**Washington State
Department of Transportation**
Paula J. Hammond
Secretary of Transportation

August 16, 2010

Subject: 12 Parcel Segregation and BLA
Segregation (SG-10-00032) Hundley
I 90, Exit 78 vicinity - Northerly side of Interchange.

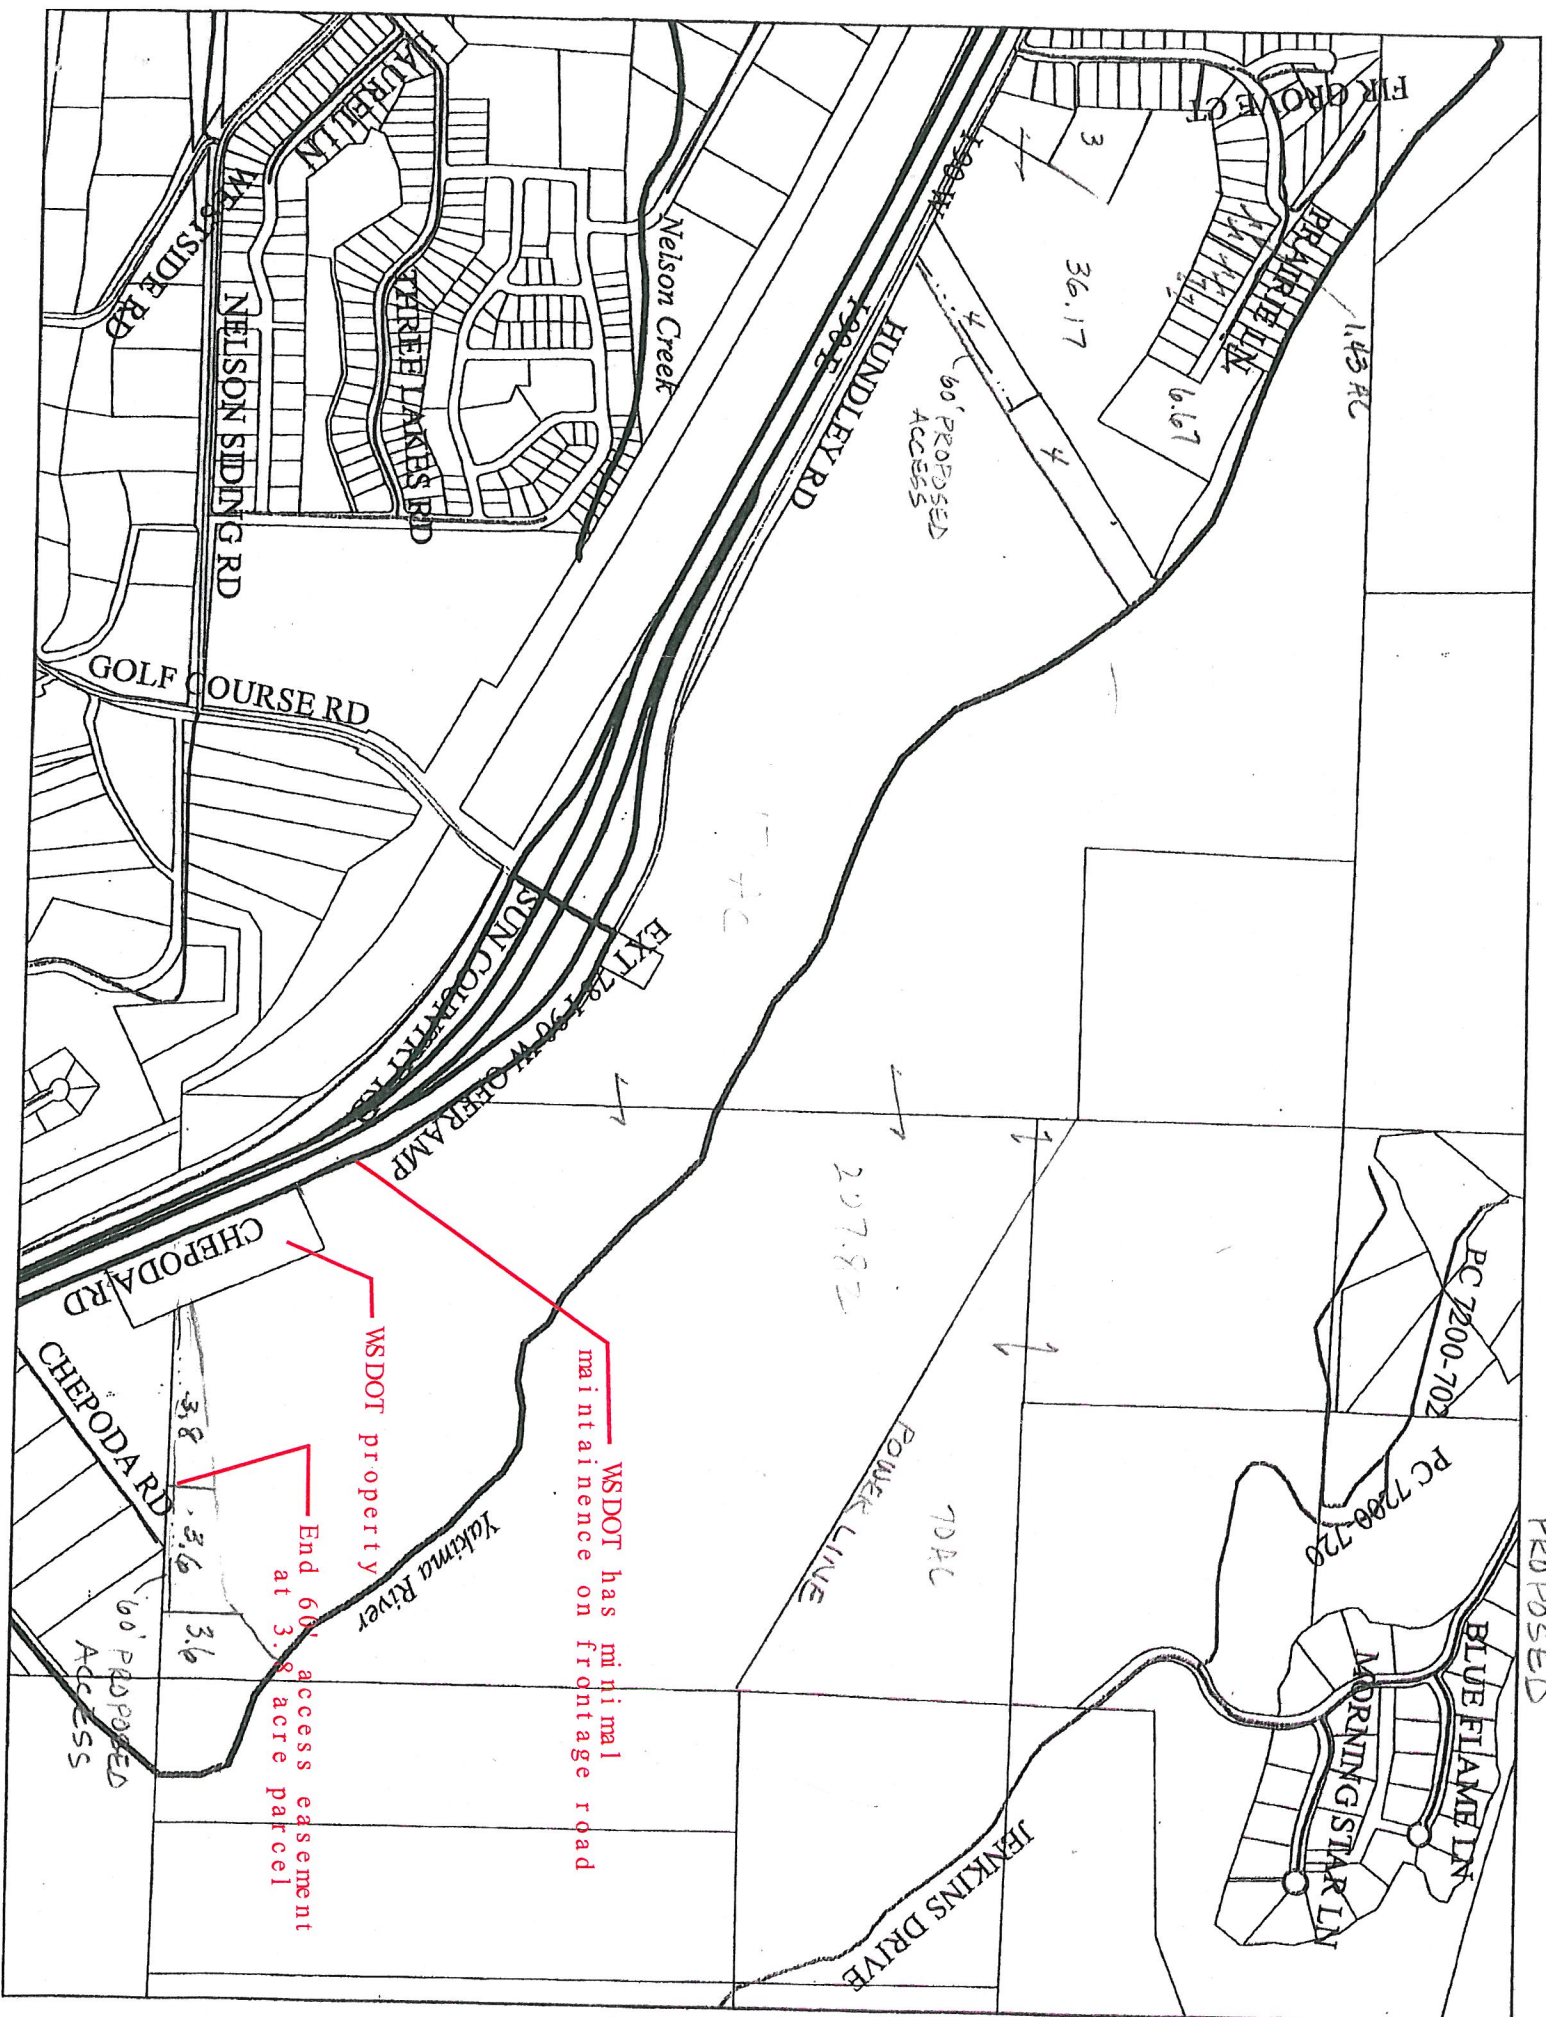
2. The 60' proposed access shown at the end of identified "Chepoda Road" must terminate at the 3.8 acre parcel, and not extend to the rectangular shaped parcel to the west that is owned by the WSDOT (see attachment). No access across this parcel owned by the WSDOT, or the haul road, will be allowed.
